KITTTITAS COUNTY COMMUNITY DEVELOPMENT SERVICES

August 29, 2006

Re: Ranch on Swauk Creek Re-Zone and Preliminary Plat

Conceptual Water Plan

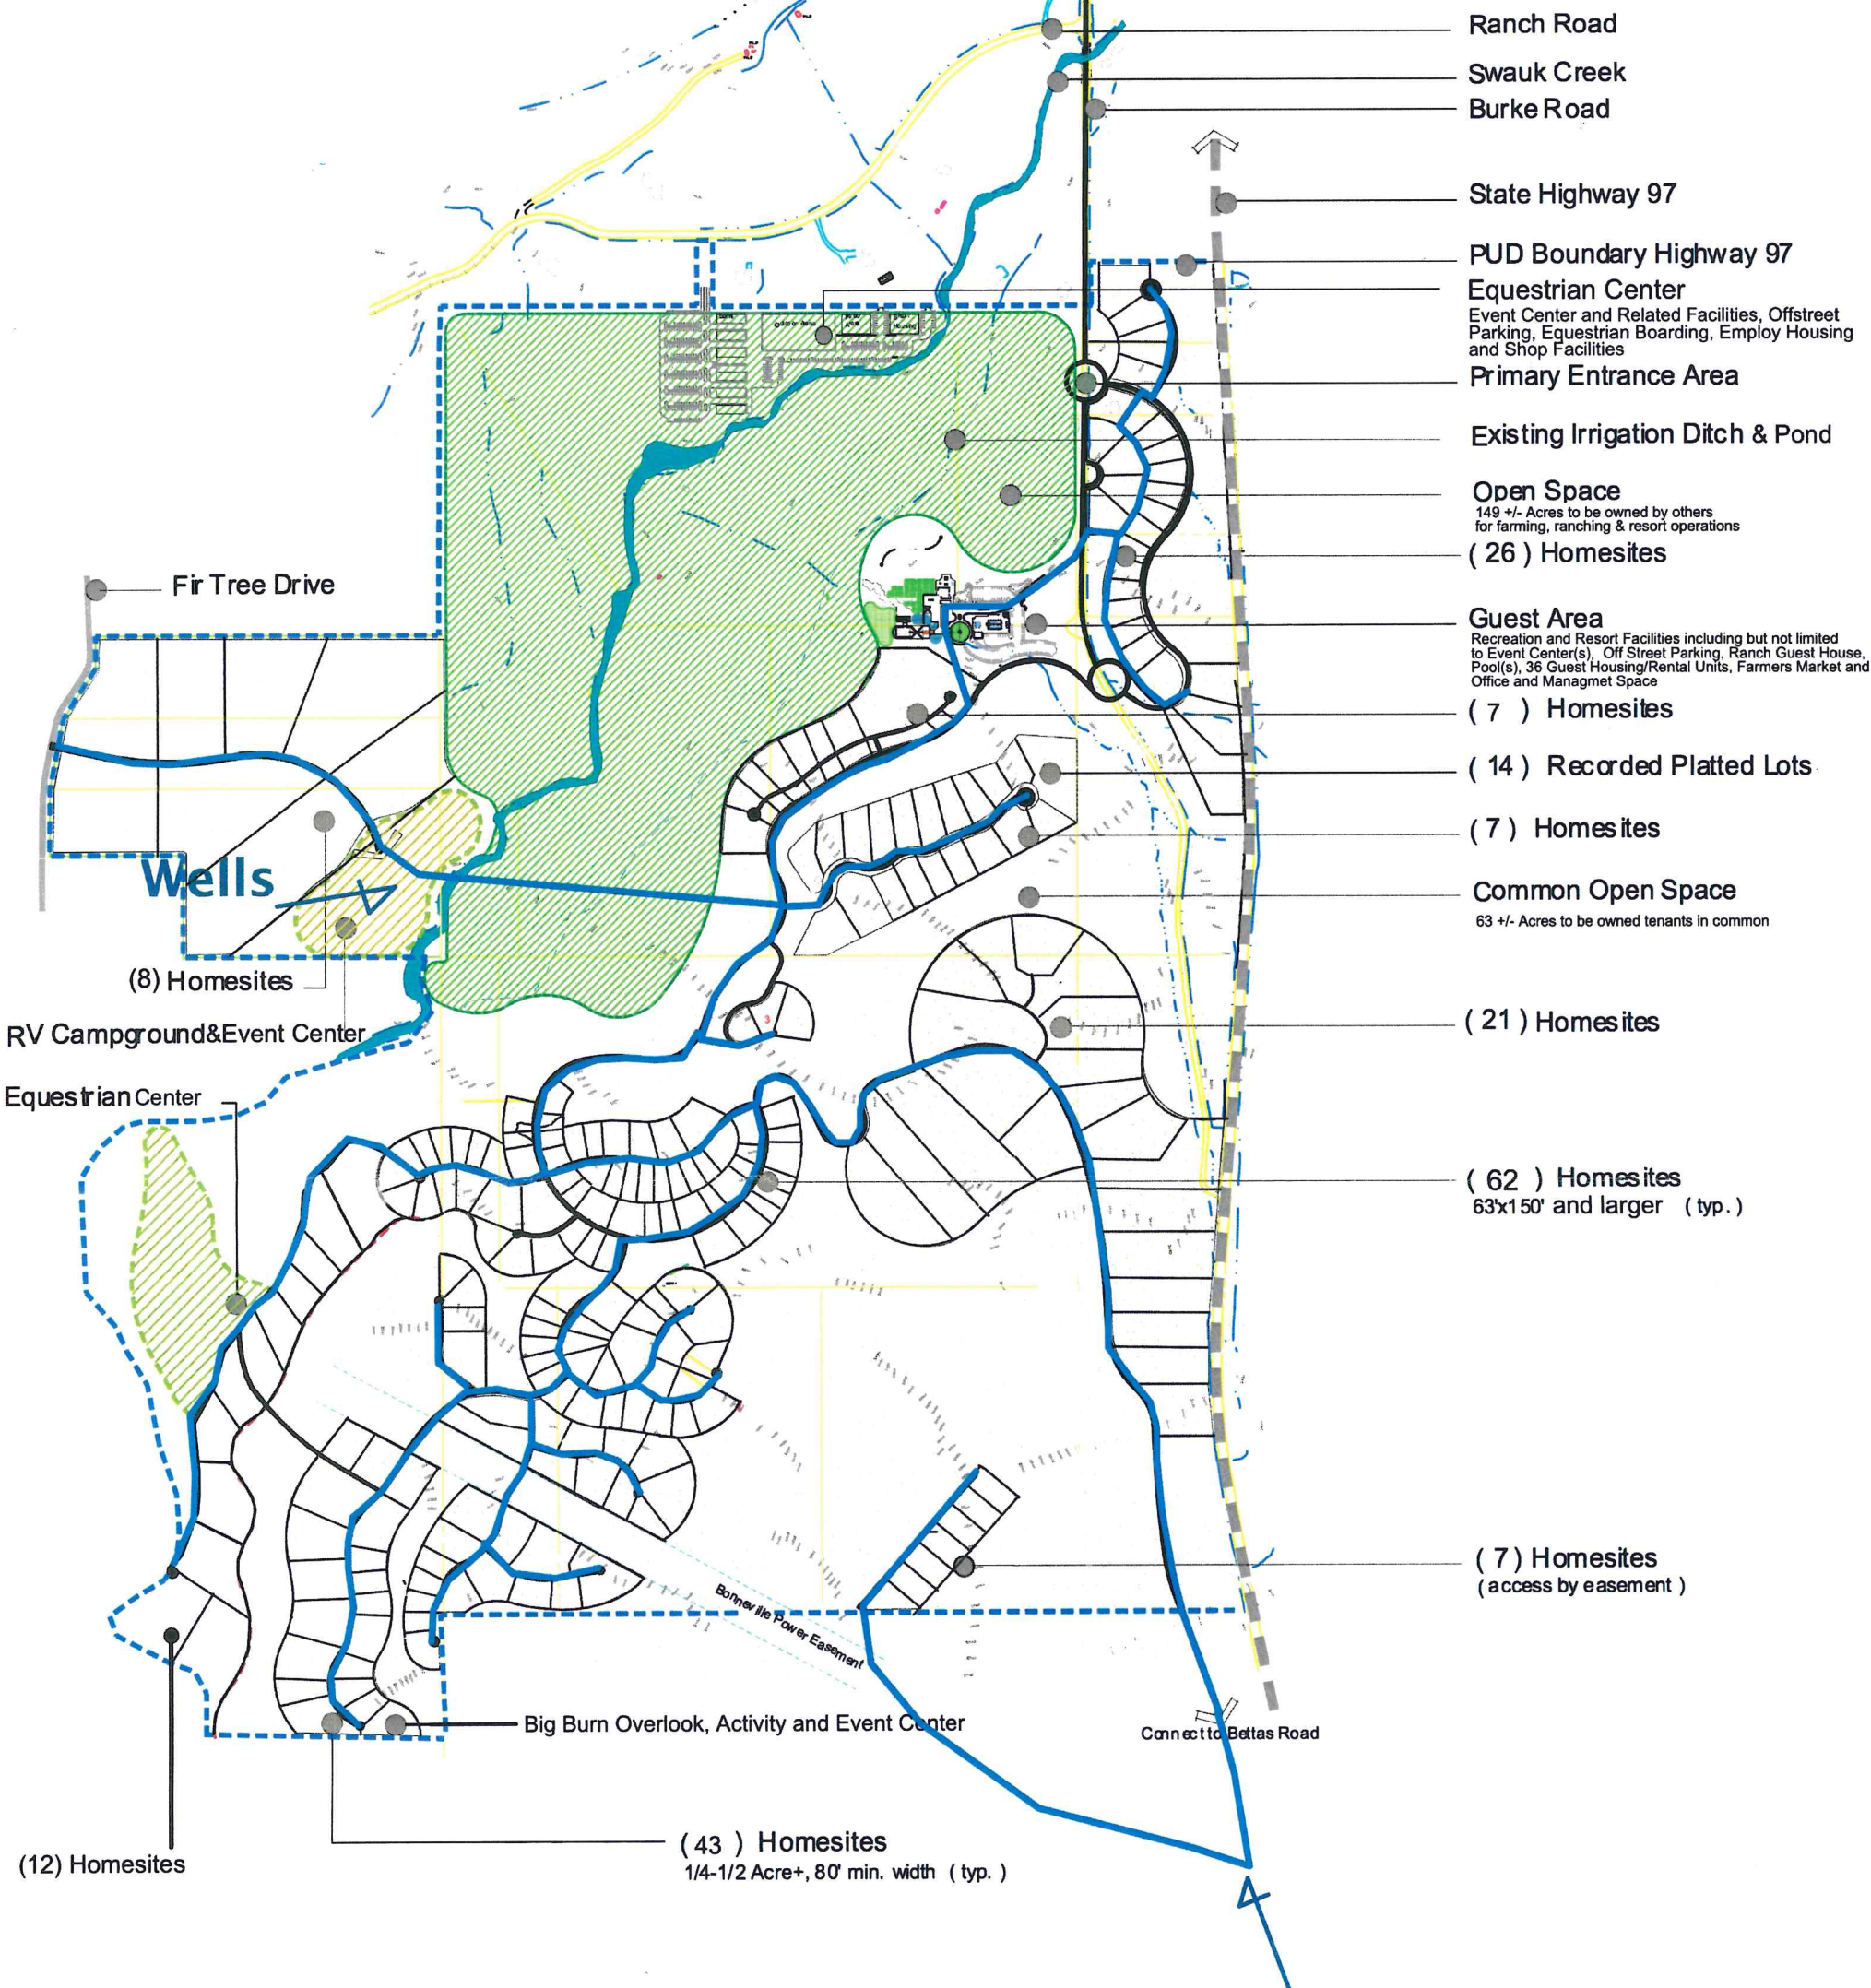
- All development in S33 T20 R17, S34 T20 R17 and portions of S27 T20 R17 are outside a fire district and subject to the International Urban Wildland Interface Code.
- Fire flow was not addressed on the preliminary plat phase 1 division. Hydrants will be required for the entirety of the project, and their placement and distribution shall comply with the International Fire Code Appendix C.
- "Fire Lane-No Parking Zone" signs may be necessary on the private/public roadways/driveways.
- All public and private roadways/driveways shall meet the minimum requirements of a fire department apparatus access road with a minimum width of twenty feet, and up to twenty six feet in width on roads with hydrants.
- All development must comply with the IFC and Appendices.
